From: Russell McCourty
Sent: 25 July 2017 12:21
To: Mark Jones
Cc: John Hinds
Subject: A/87/17/HH & A/88/17/L

Following comments from Ian Wightman, we have amended the main elevation as per the attached.

PROPOSED ELEVATION 1:50

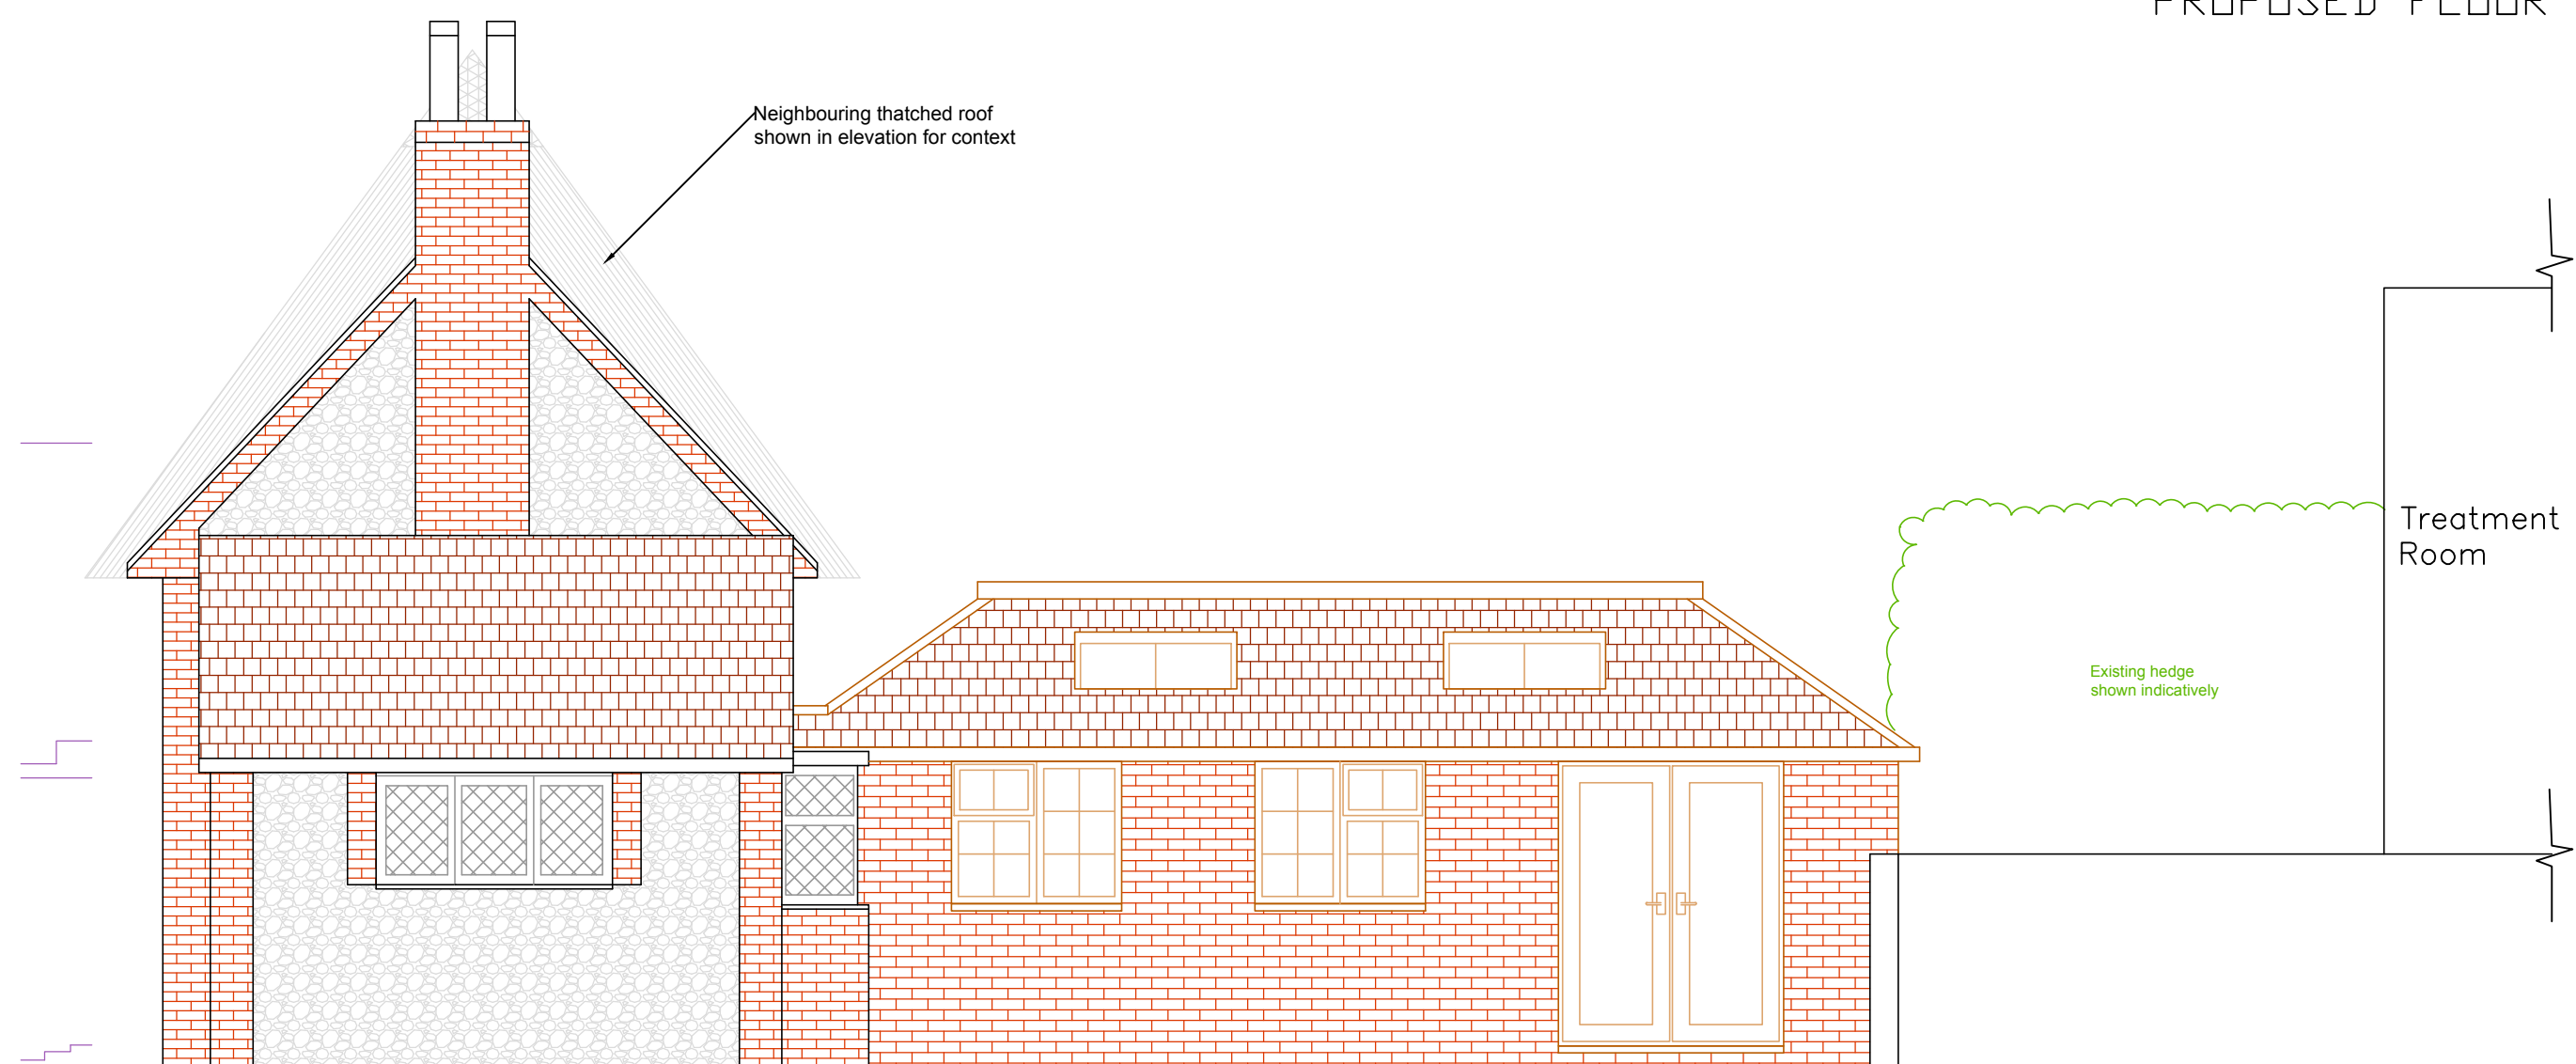
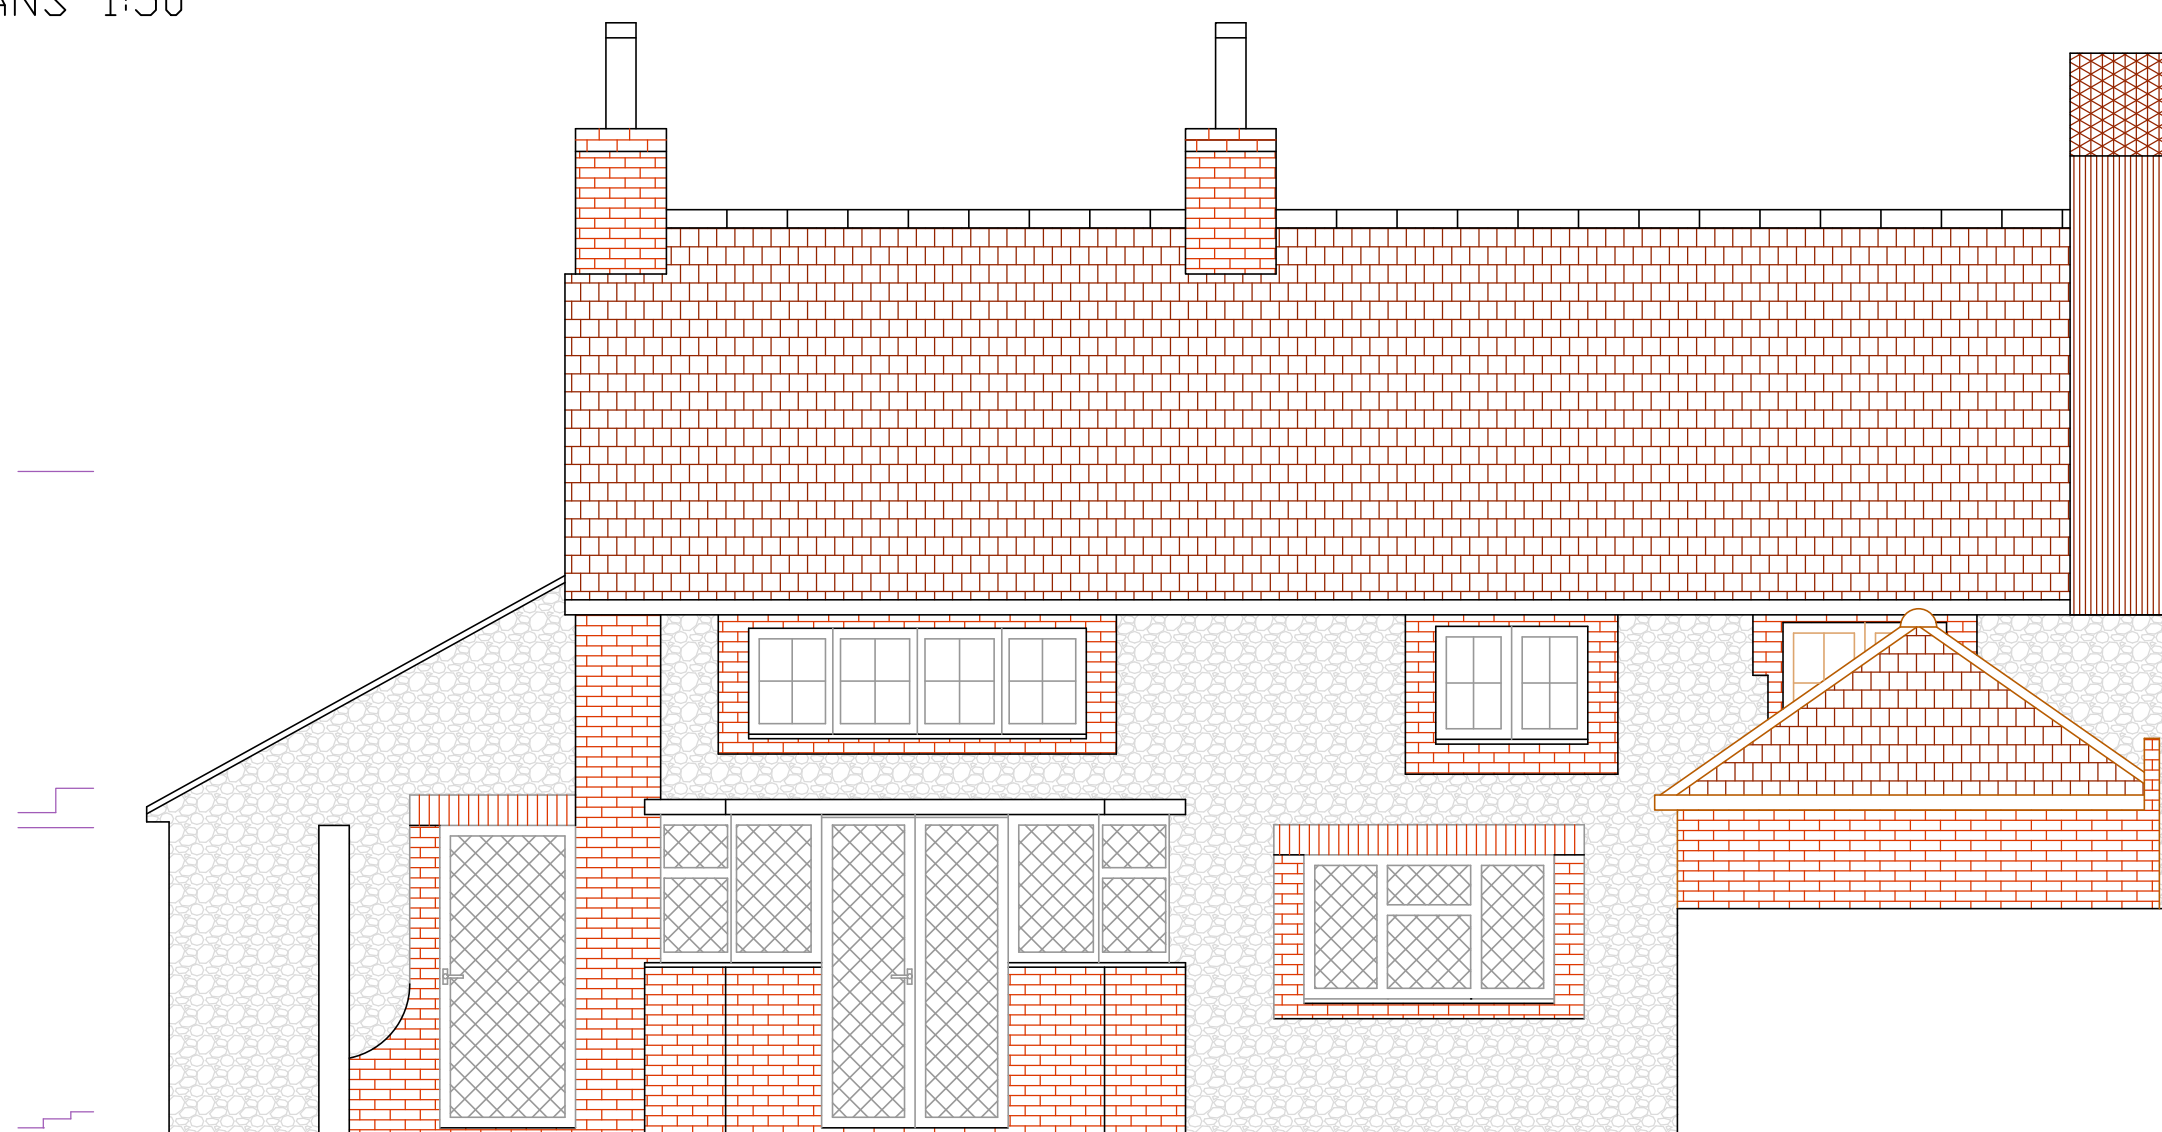
Proposed windows and doors are to be hardwood, painted white and fitted with slim double-glazing (10-12mm). Window style to be in small panes as per the elevations (to match the existing main property).
